WISWELL PARISH COUNCIL

Planning Application No: 3/2013/0212

Application for proposed replacement two-storey dwelling following demolition of existing bungalow (re-submission)

Shay Cross, Old Back Lane, Wiswell, Lancashire, BB7 9BS

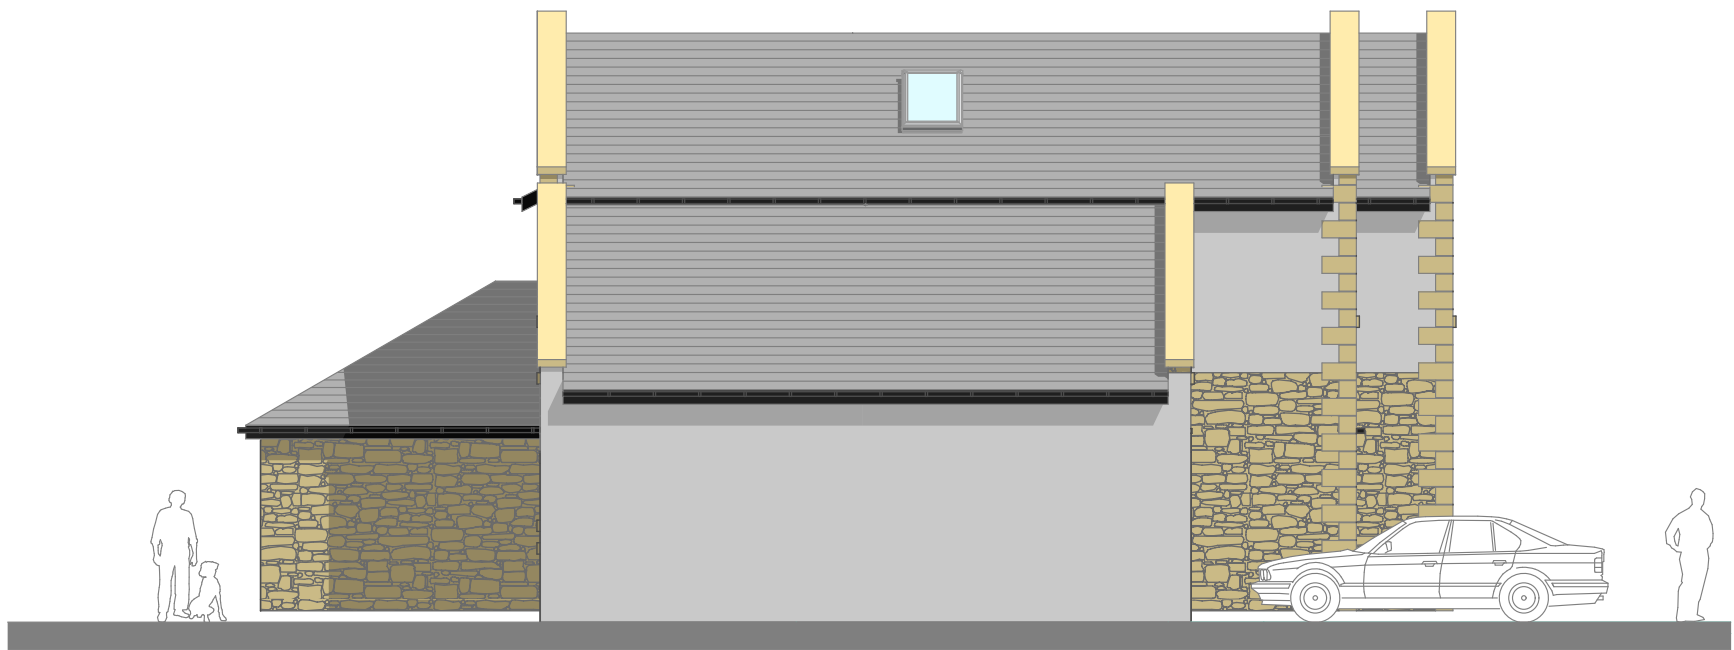
The above application has now been considered by Members of the Parish Council. They object to the application on the grounds that it would be detrimental to the present street scene due to its size and massing.

Members are concerned that the proposed dwelling is not consistent with neighbouring properties as the ridge height is well above the neighbouring property at Braeside.
